# ● Recommendation Report

Application No. BE/52/11

**Proposal: Ground floor extension (re-submission following BE/36/10/).**  
**Site: 1 David's Close, Bognor Regis, West Sussex PO21 5TR.**  
**BE/52/11/**

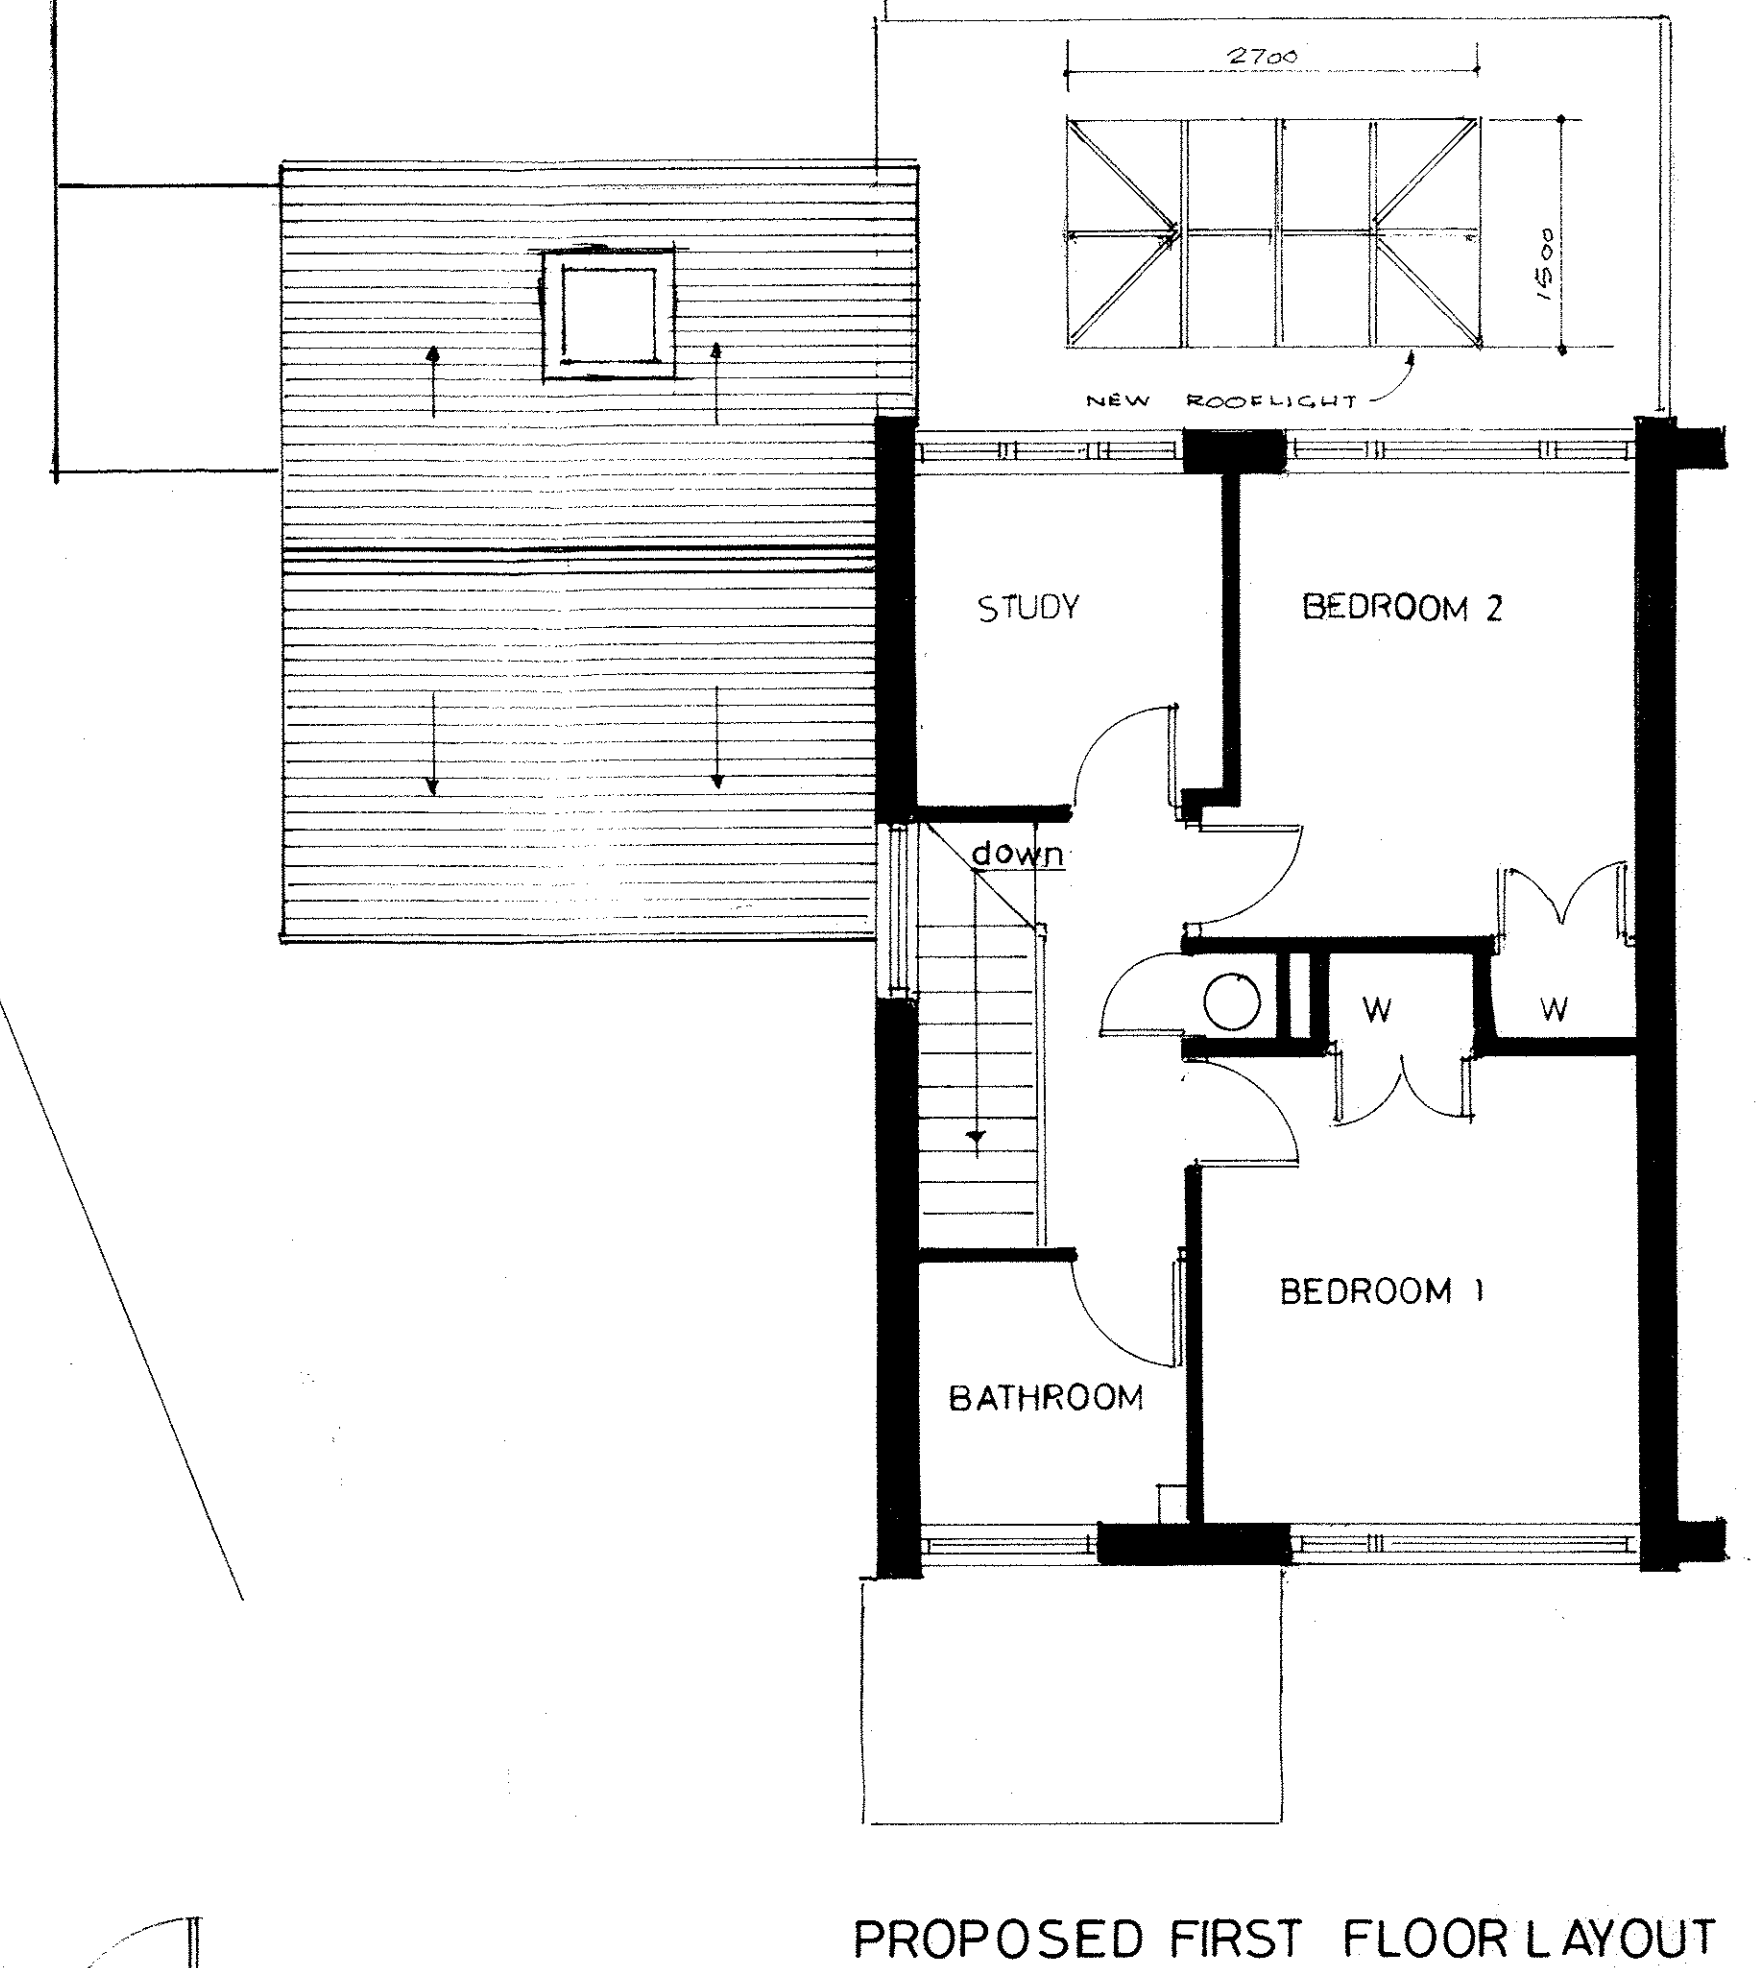
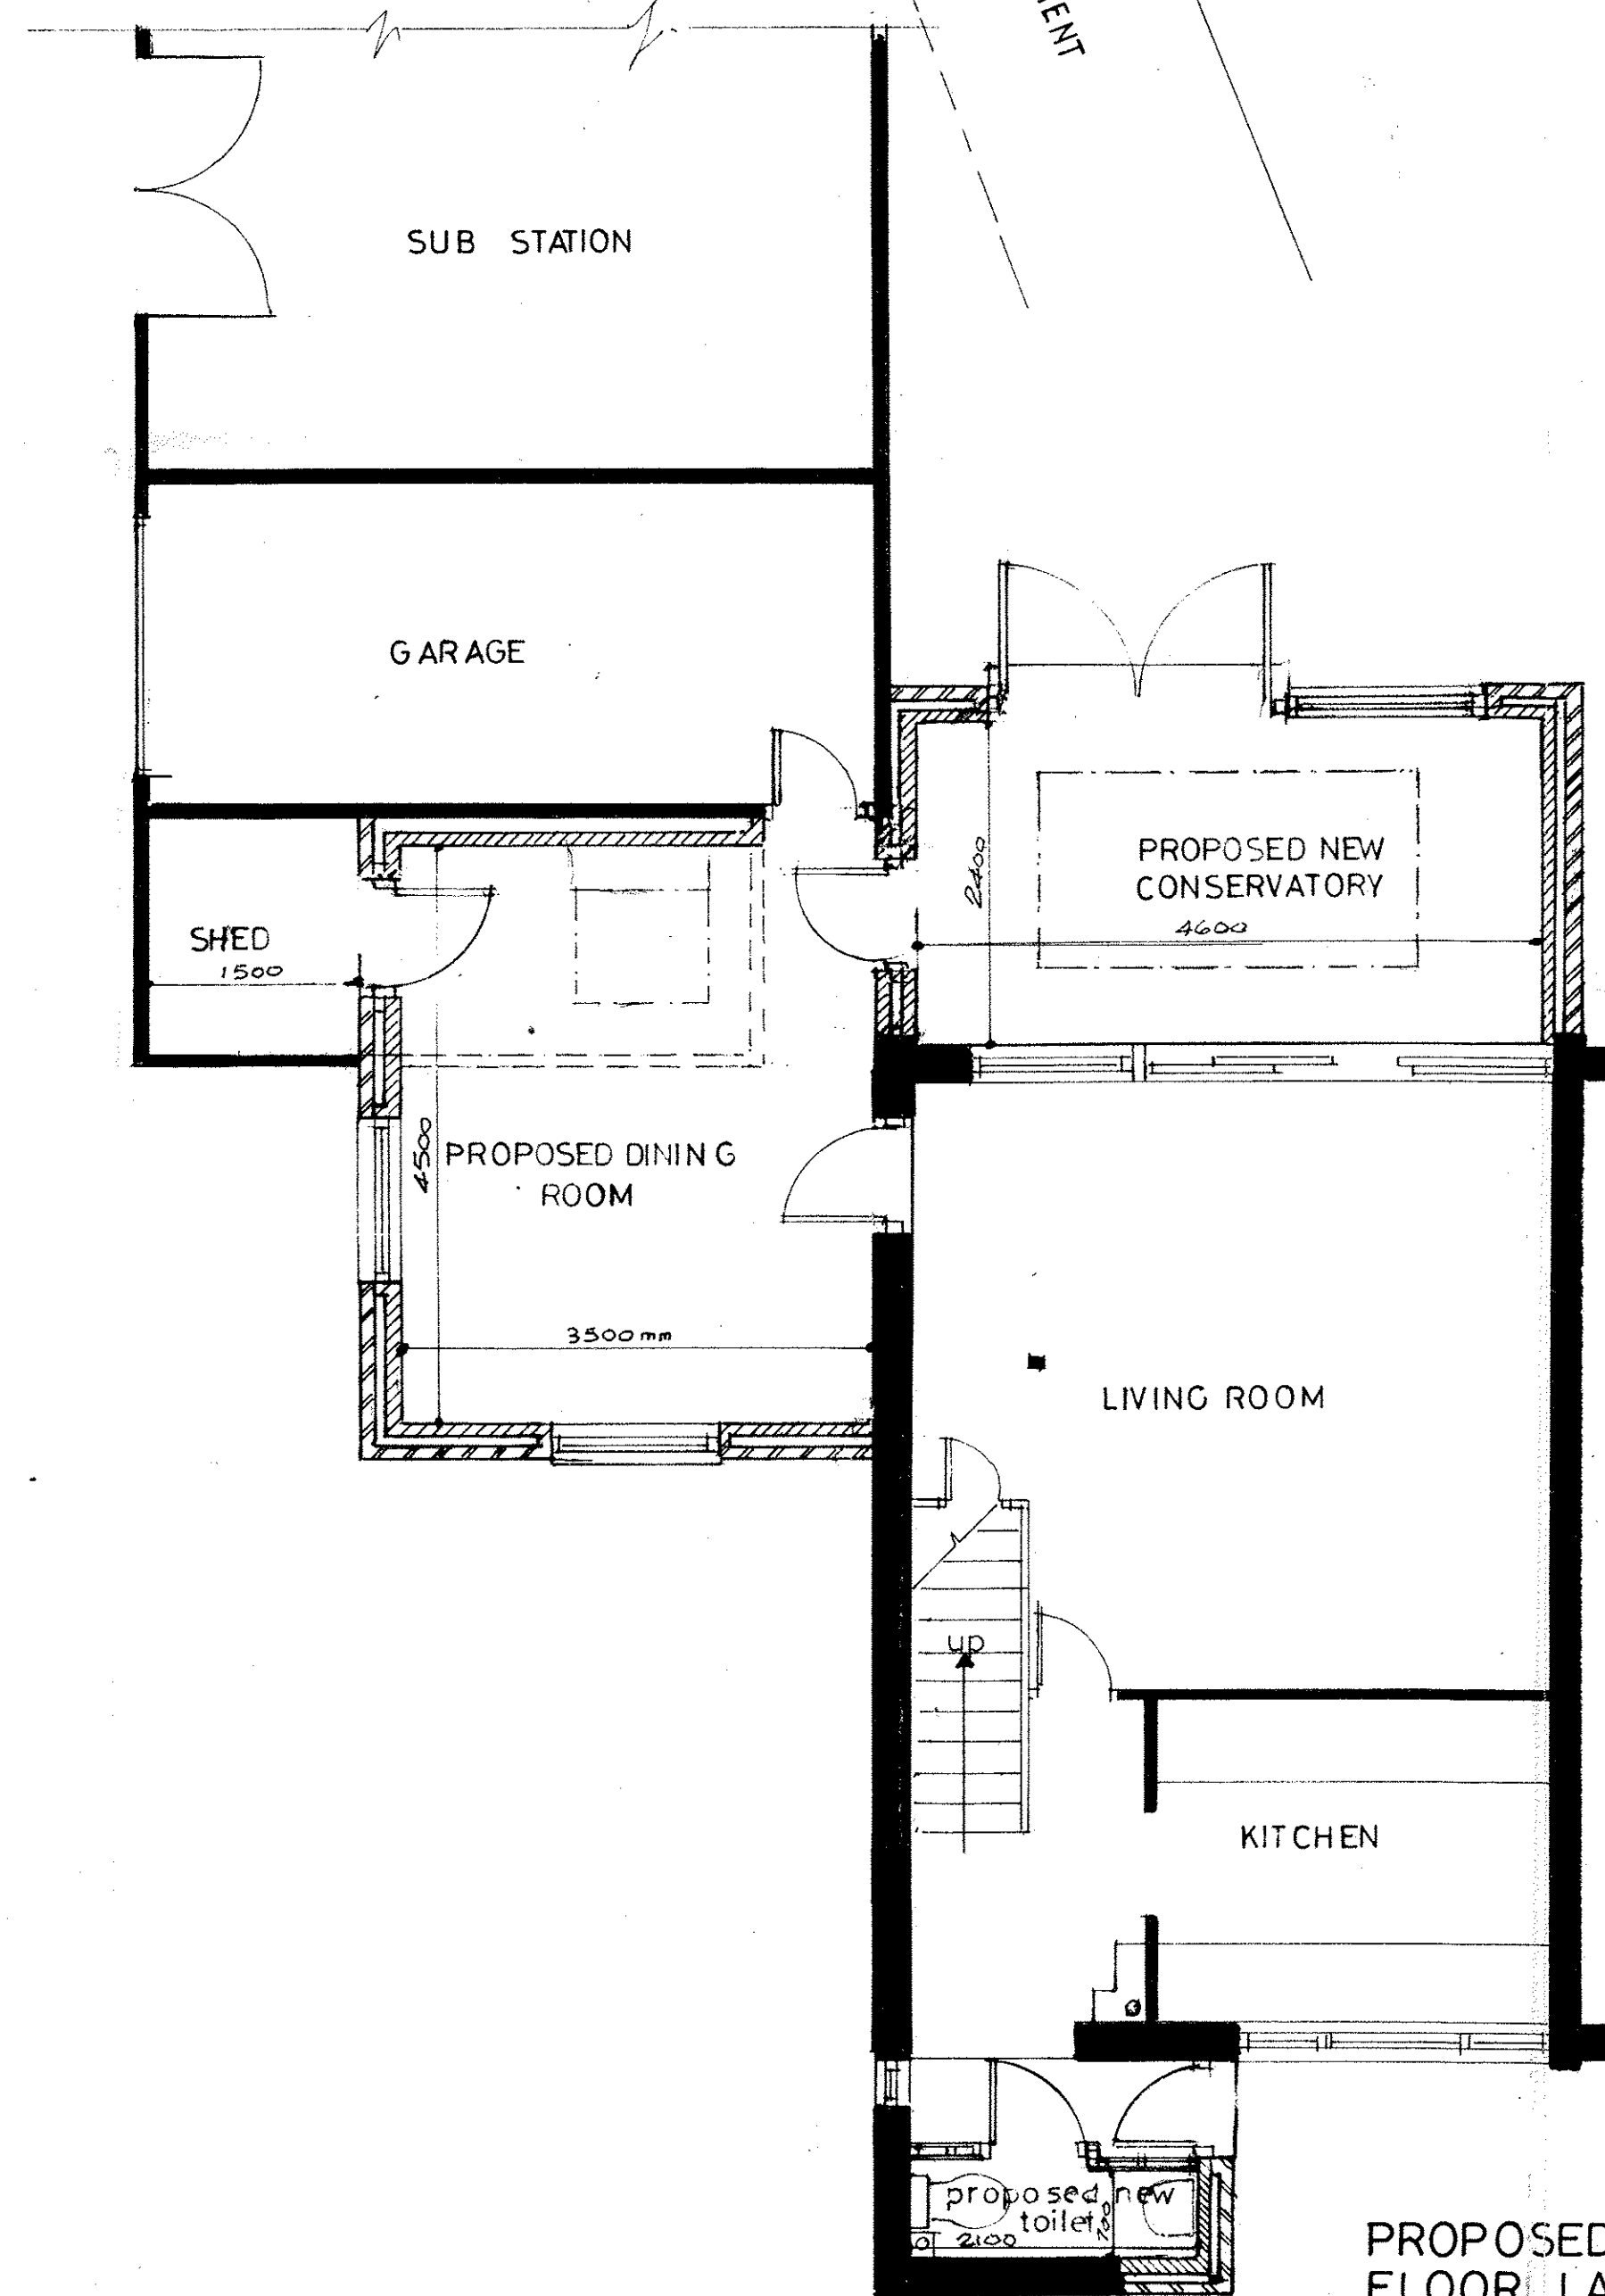
Please note that there are a 150mm public foul sewer crossing the site. No development or new tree planting should be located within 3 metres either side of the centreline of the public sewer and all existing infrastructure should be protected during the course of construction works.
